Our Ref: SYD19/01630/02
DPIE Ref: SSD-10407

**SSD-10407L EXHIBITION OF ENVIRONMENTAL IMPACT STATEMENT (EIS)
LIQUID WASTE TREATMENT PLANT
14-16 KIORA CRESCENT, YENNORA**

TAB A

Figure 2.1. Swept paths for heavy vehicles accessing the site at 14- 16 Kiora Crescent, Yennora. NSW Surveys PTY LTD, 8/11/19.

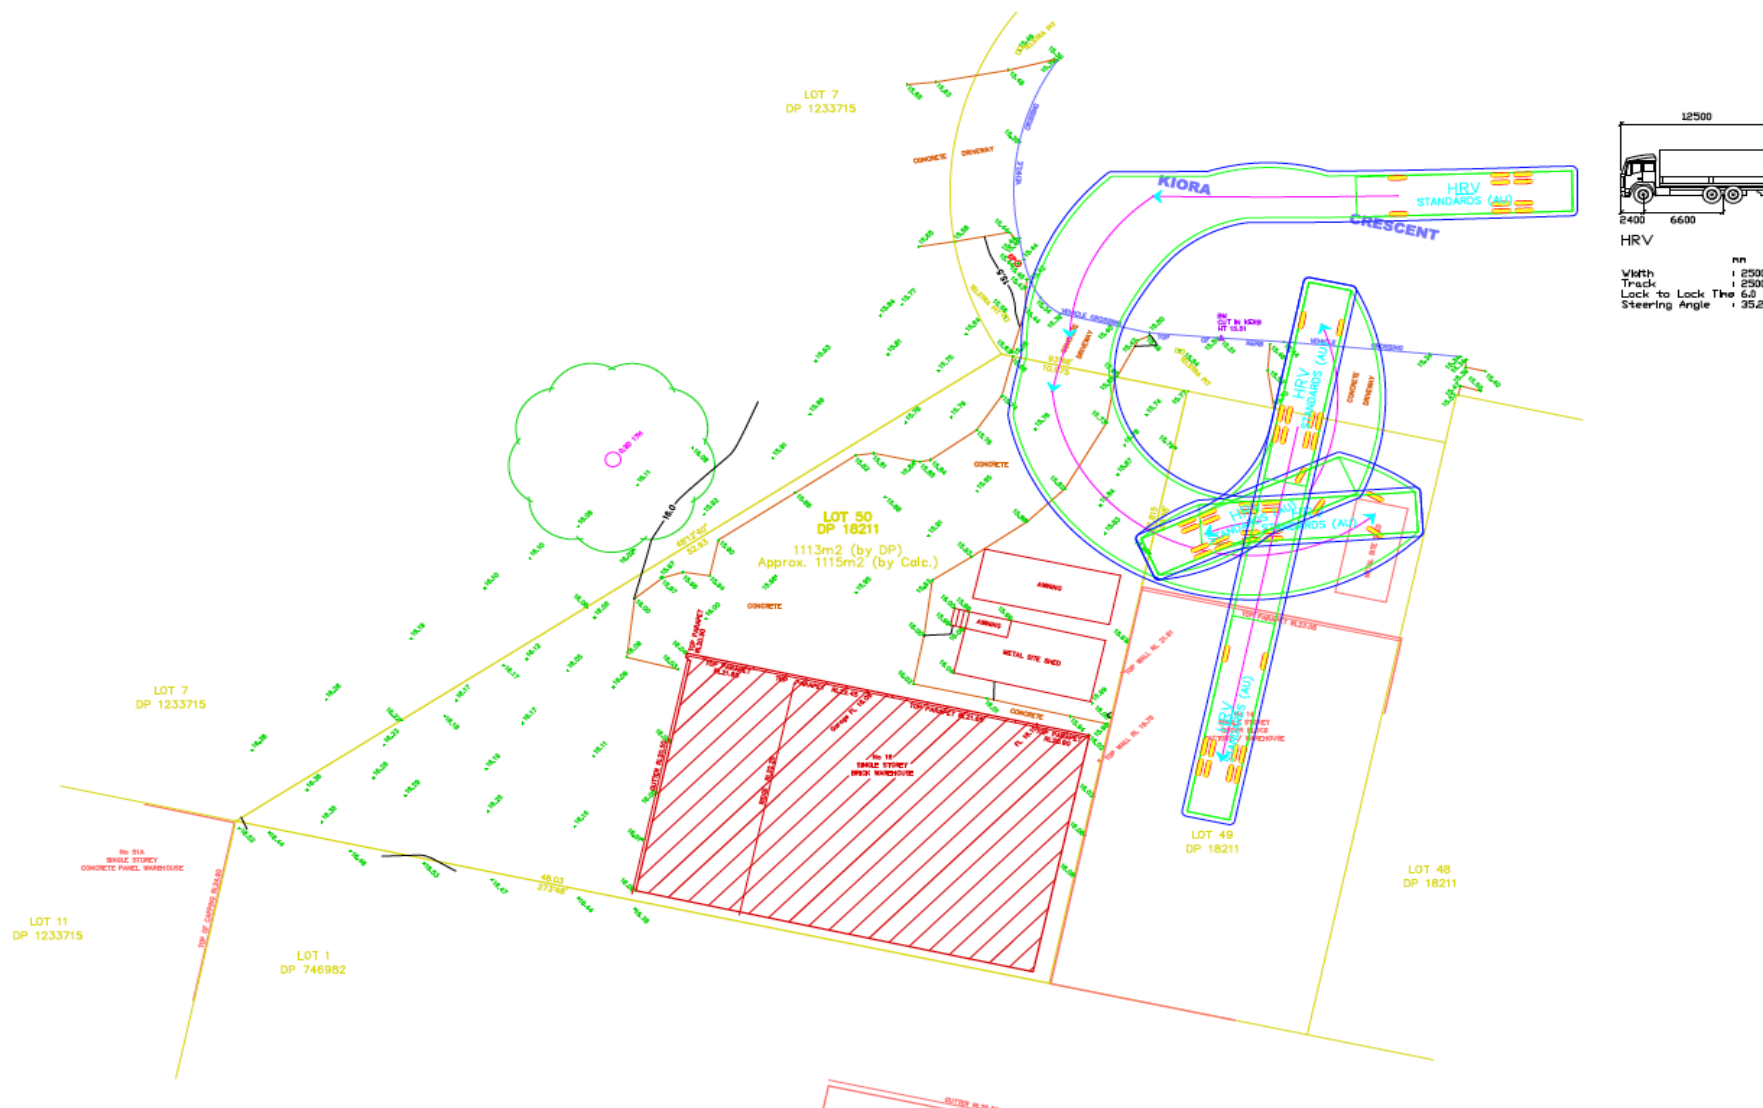
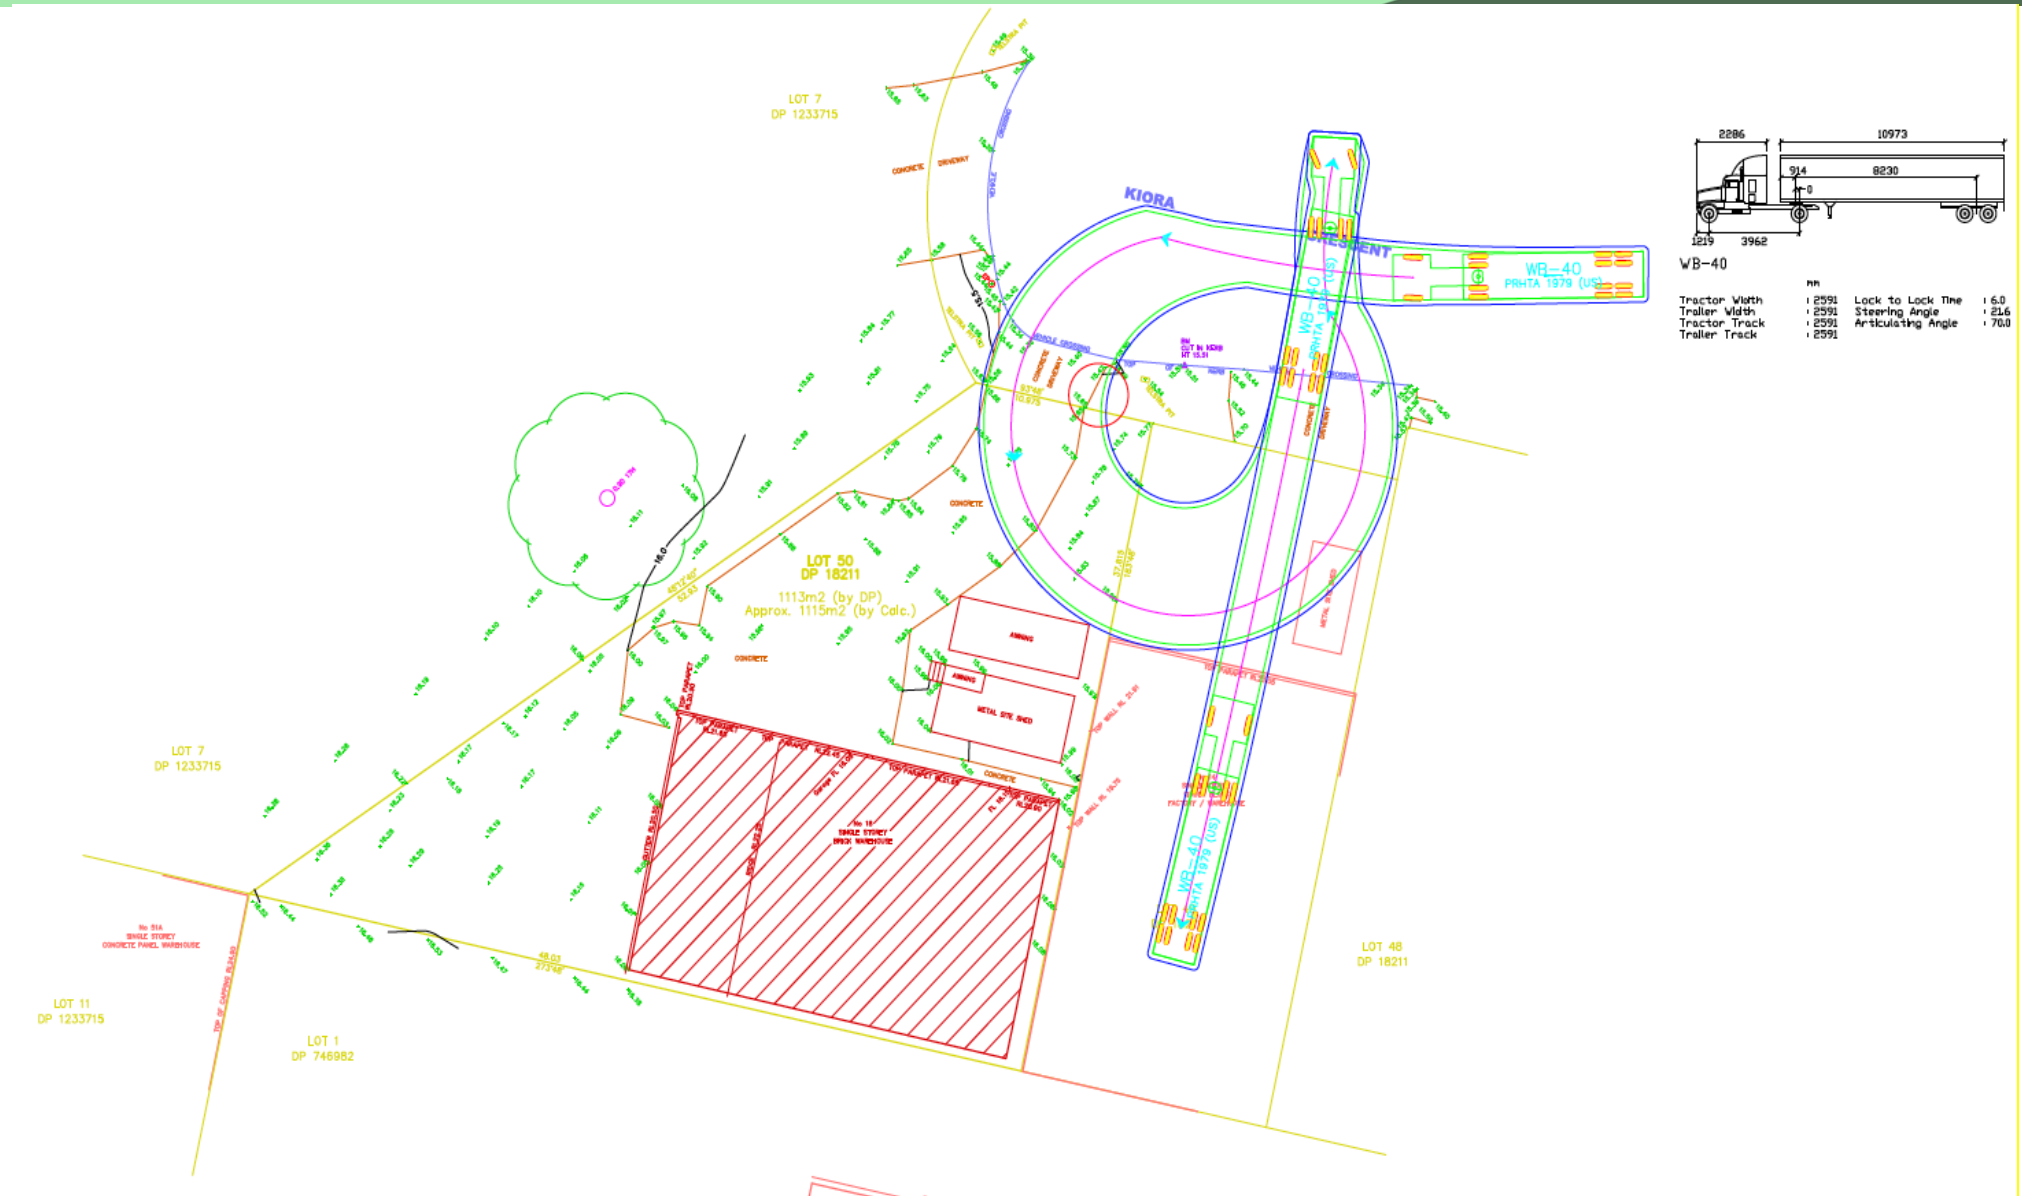
TfNSW notes that the swept path diagram (Appendix 8C) shows that the incoming trucks will be required to manoeuvre out of the 14 Kiora Crescent vehicle crossover, before reversing into the site.

As Kiora Crescent is under the care and control of Council, the proposed swept path design of the vehicle movements should be in accordance with Council's requirements. TfNSW requests that this addressed as part of the Response to Submissions (RtS).
